City of Albuquerque

HYDROLOGY SECTION

November 28, 1986

On November 26, 1986, I conducted a field inspection of the Car Quest project site after receiving the revised drainage plan, dated November 5, 1986. During my inspection, I noted several items which appear to be contrary to the design of the approved plan.

GRADING AND DRAINAGE PLAN
CAR QUEST AUTO PARTS STORE
1321 SECOND STREET NW
ALBUQUERQUE, NEW MEXICO

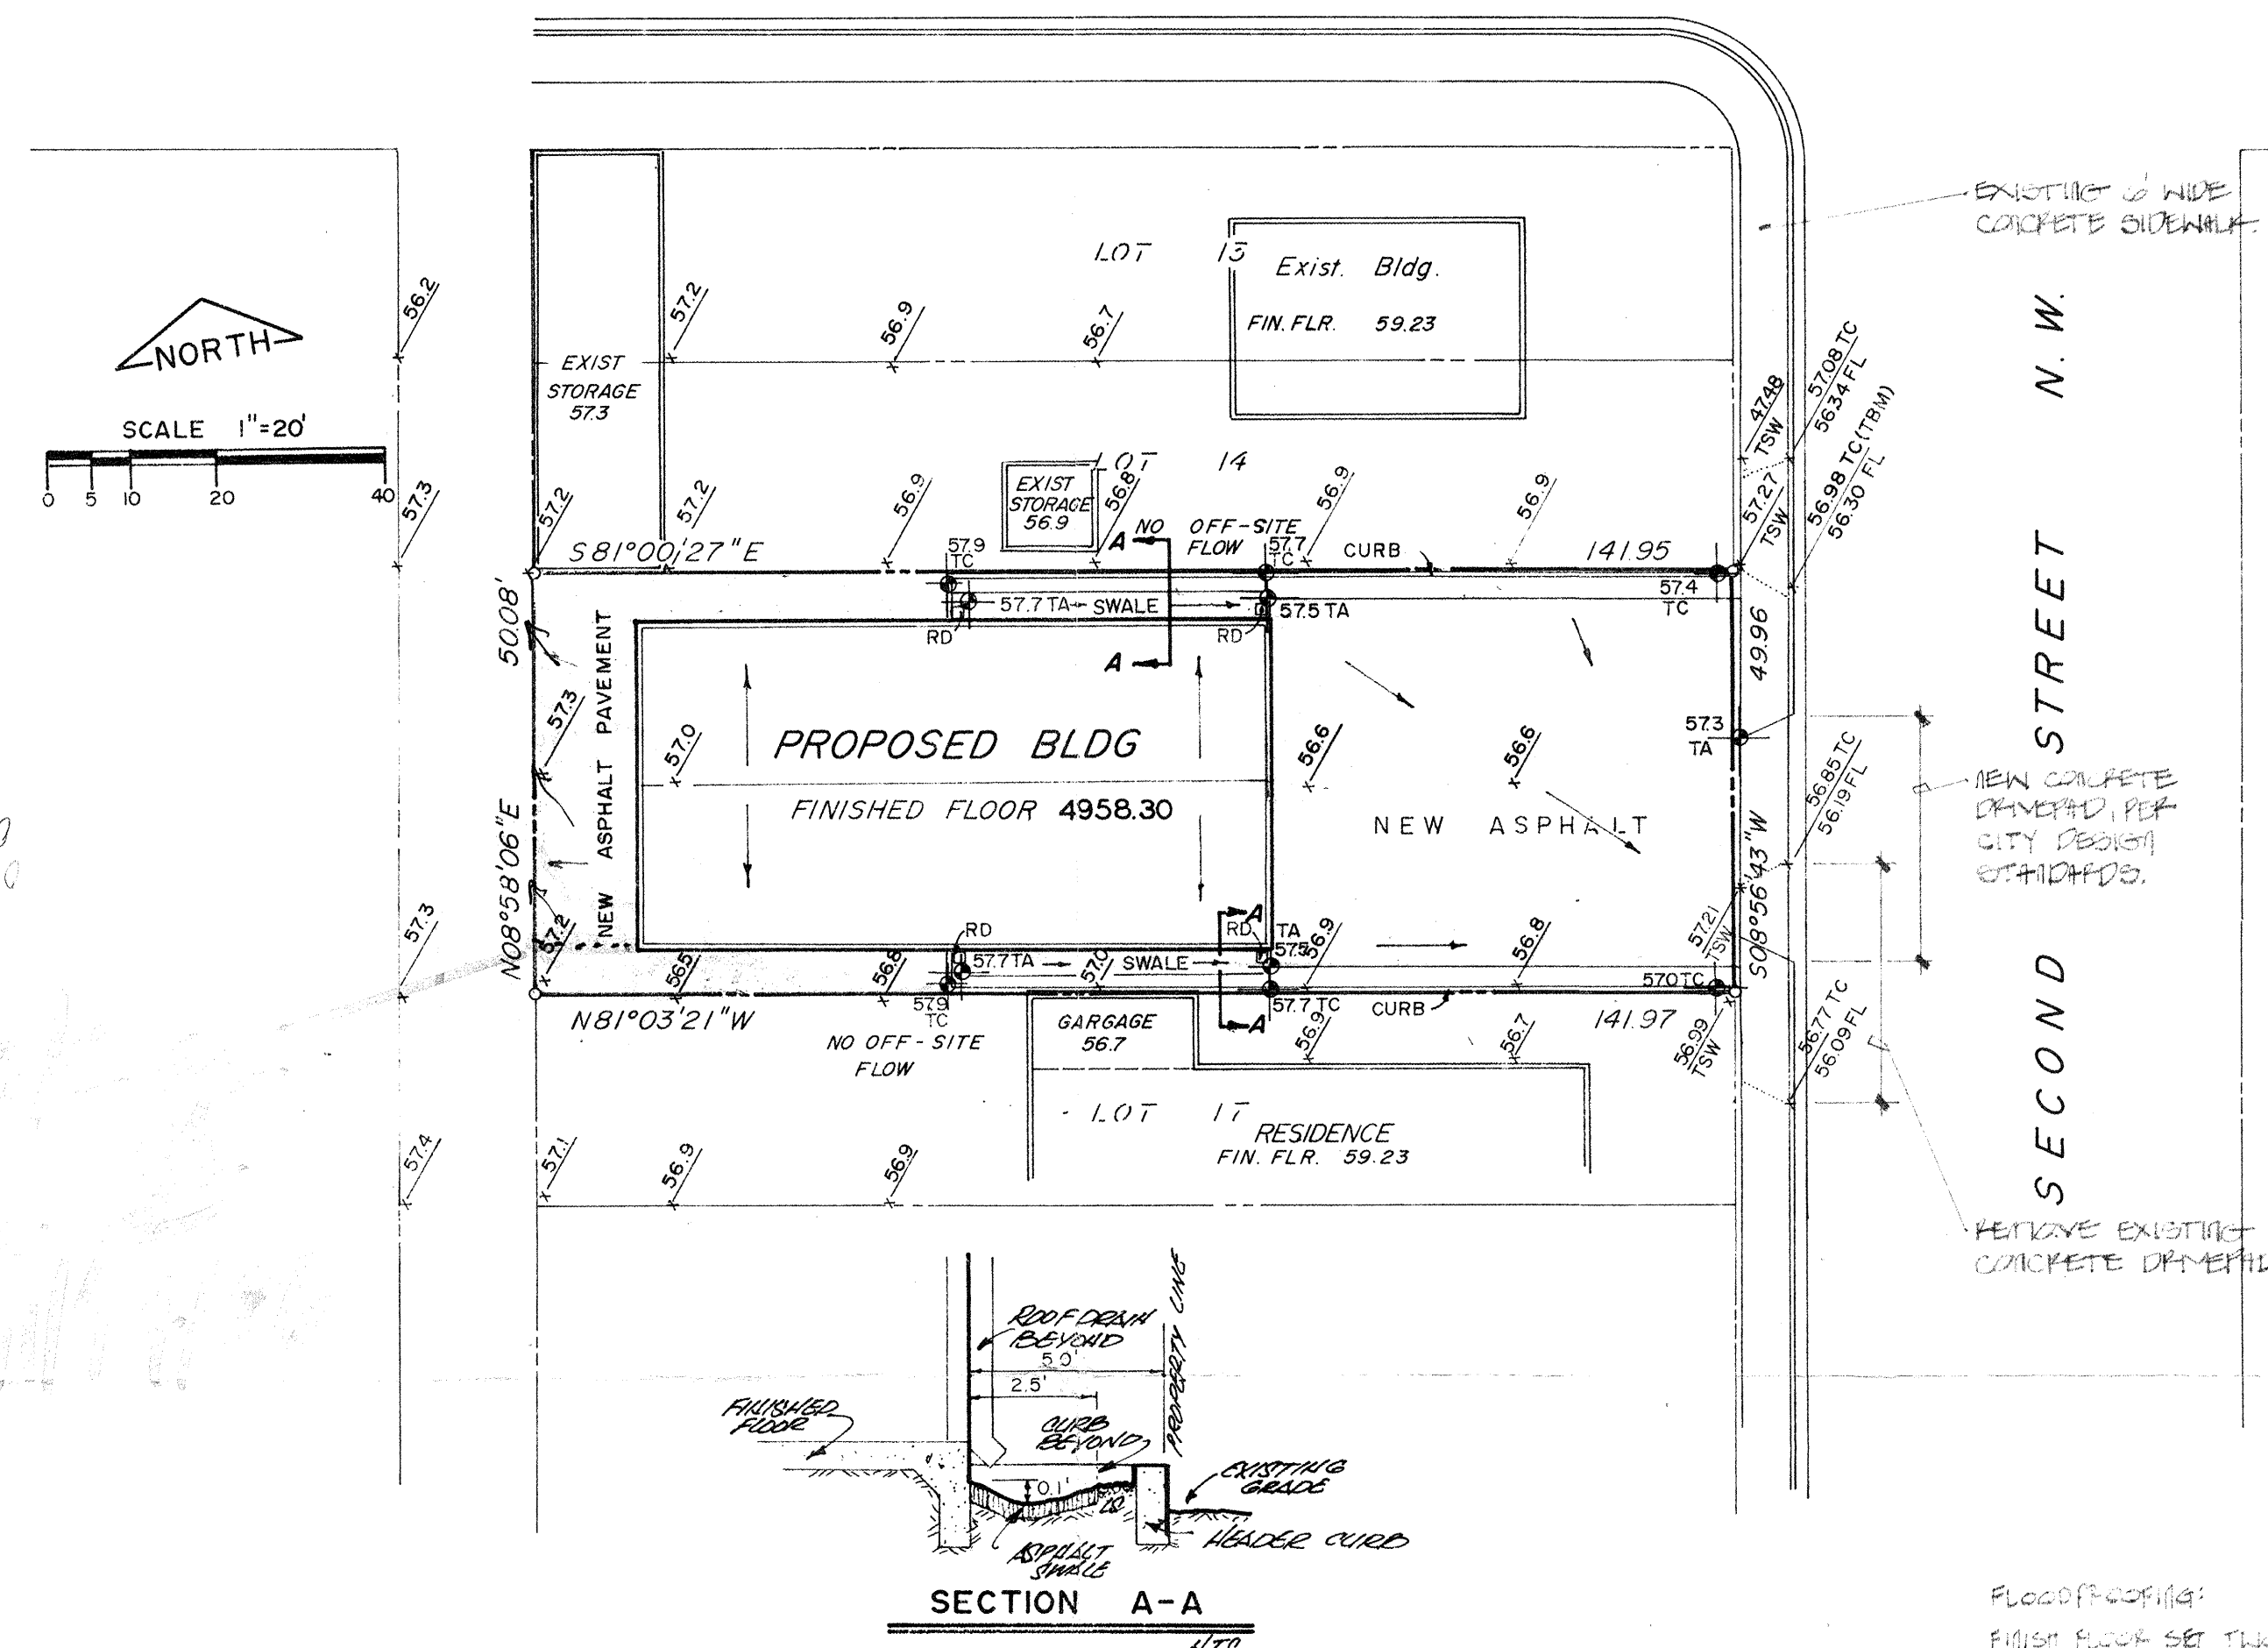
1. Drainage swale along the north side of the building is not containing roof drainage on-site.
2. Down spout extensions at north side of building is routing water onto adjacent property to north.
3. Down spout at south side of building is draining water onto adjacent property to south.

Prior to issuance of Certificate of Occupancy, these items must be corrected.
